Rezoning Transportation Analysis

Petition Number: 2020-155

General Location Identifier: Tax ID: 20103222

Date	Description
11-30-2020	First Review (KP)

DATE	August 31, 2020
SCALE	1" = 30'
JOB NO.	20200807
SHEET	RZ-01

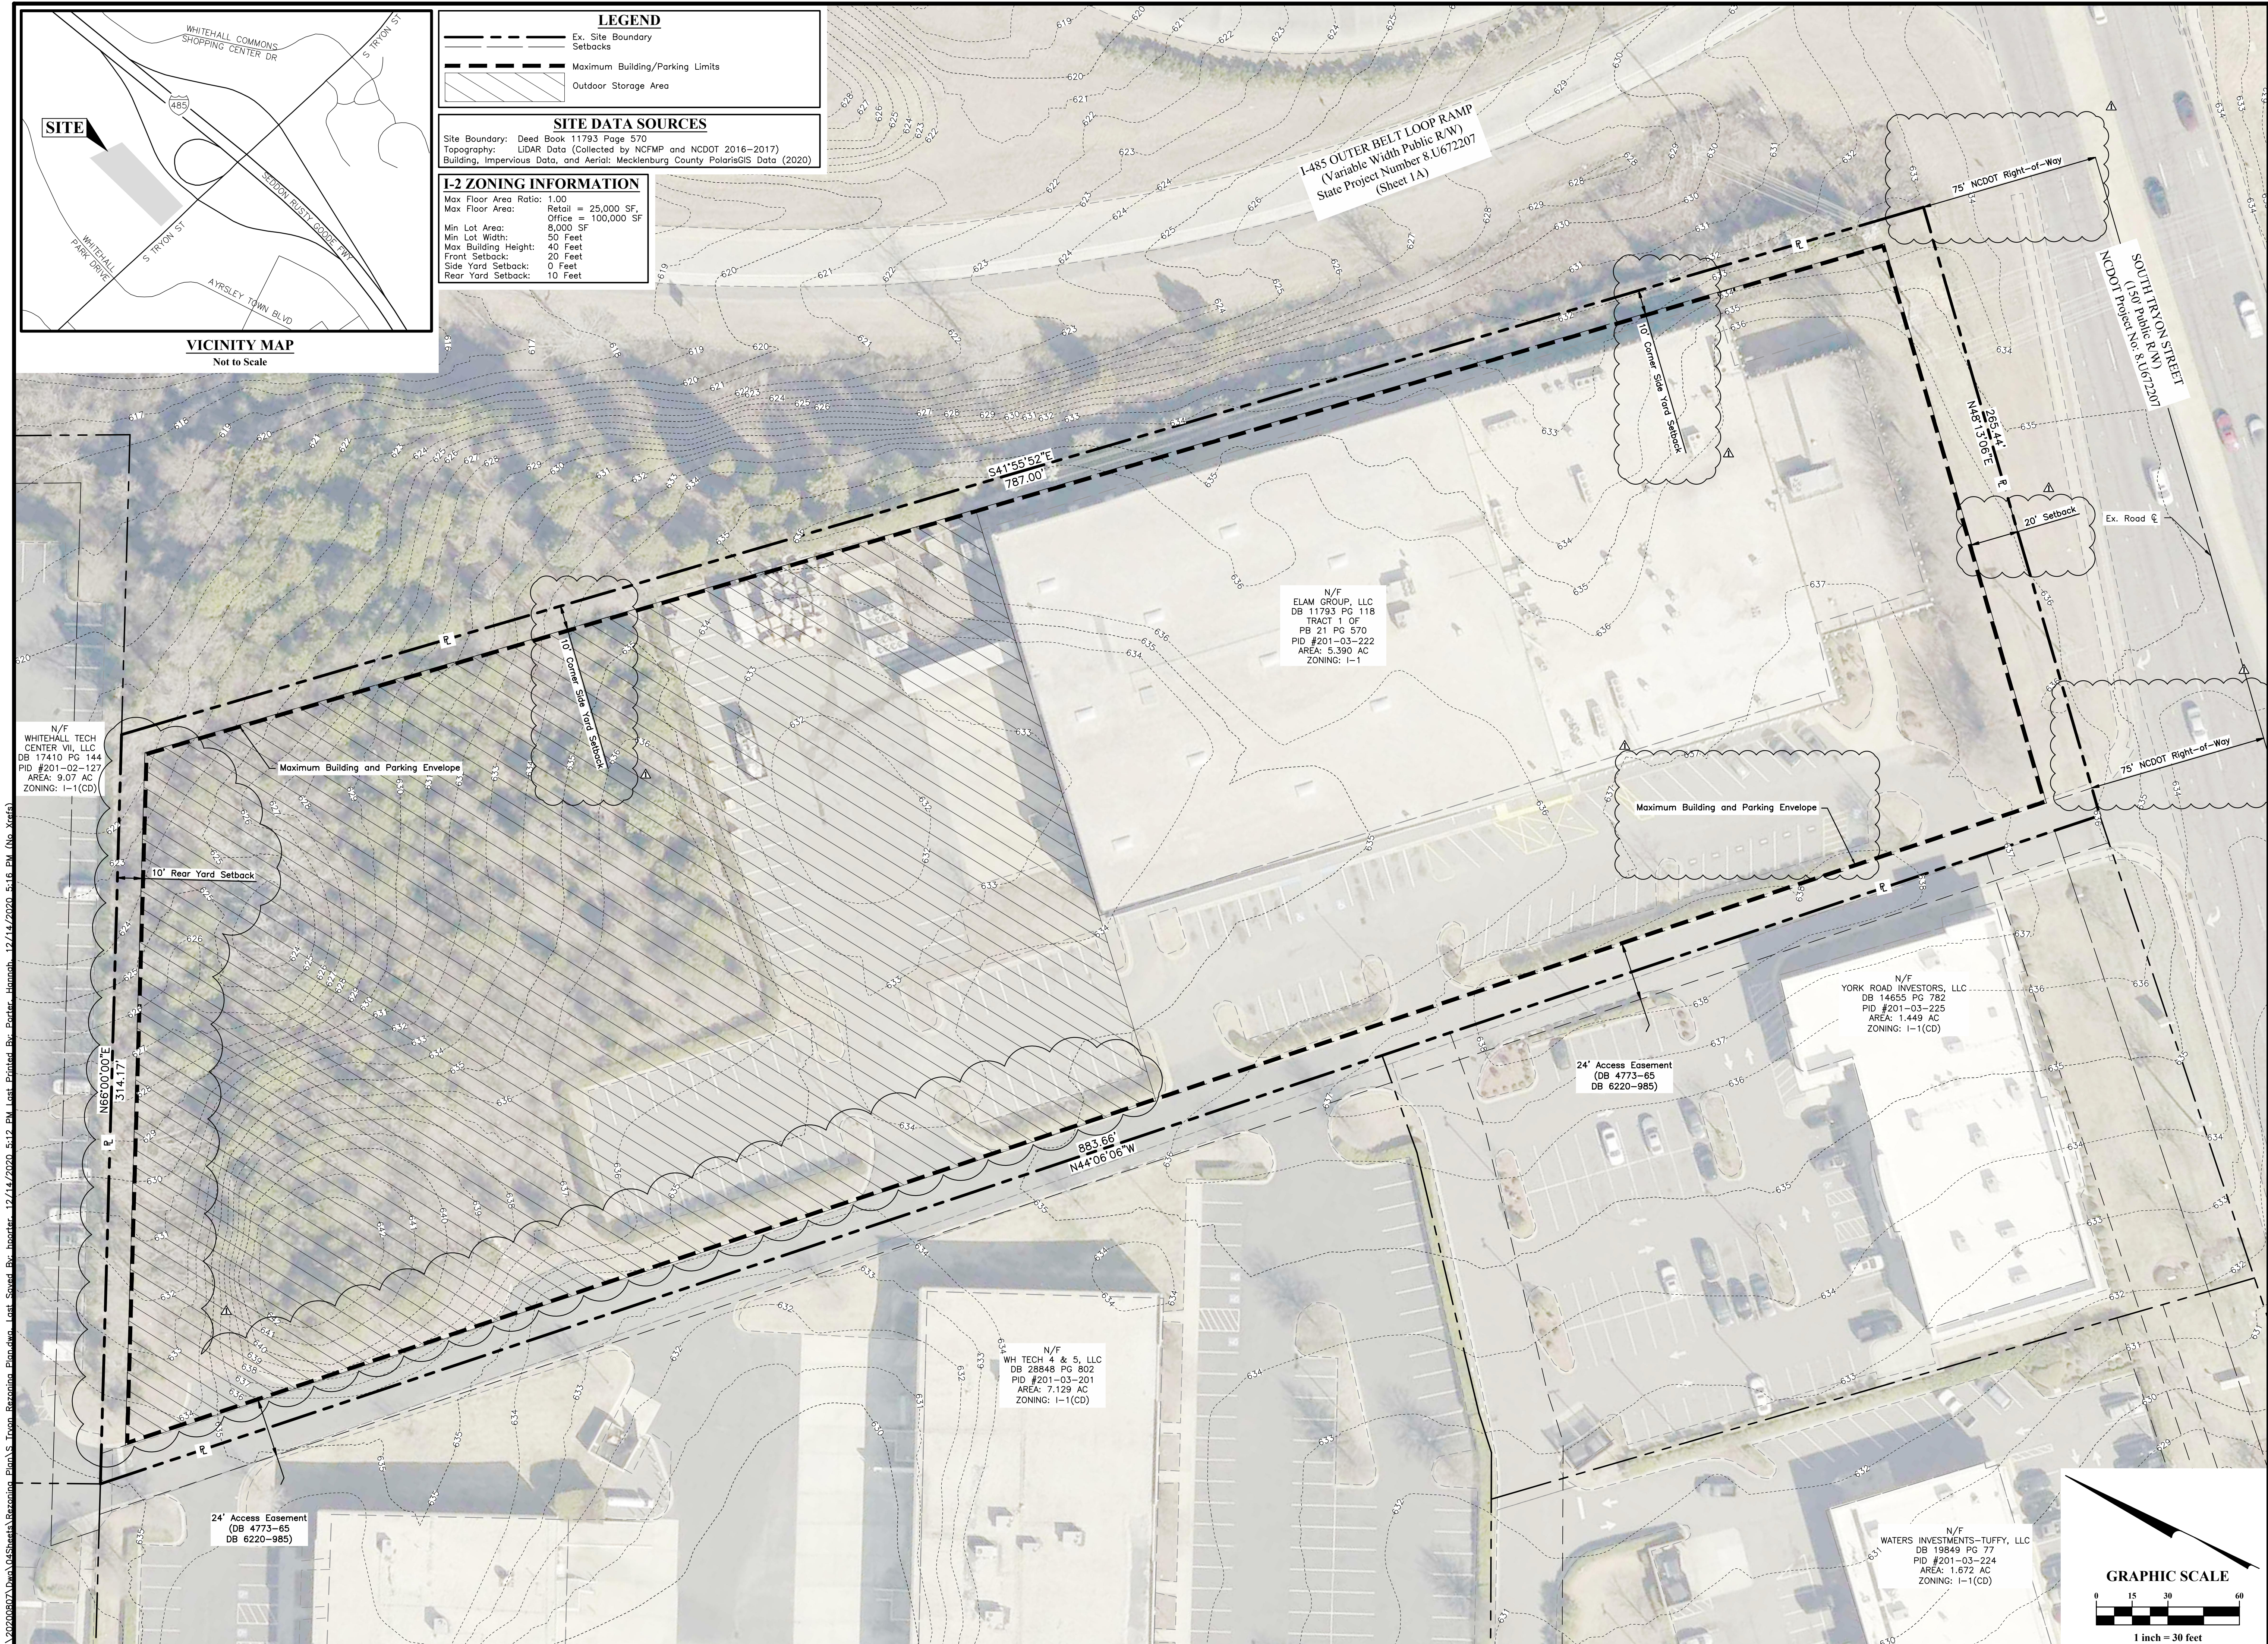
South Tryon Street: The future location of curb and gutter will need to be confirmed with NCDOT's future NC-49 (Tryon St.) and I-485 Interchange Improvement project.

Label and dimension the future curb and gutter from the centerline to back of curb.

3. Revise site plan and conditional note(s) to commit to dedicate a minimum of 75-foot right-of-way from the road centerline, if not already provided by the existing right-of-way, as shown on the site plan. The site plan shall label and dimension the right-of-way from the road centerline. Confirm the right-of-way needs with NCDOT for the future NC-49 (Tryon St.) and I-485 Interchange Improvement project.
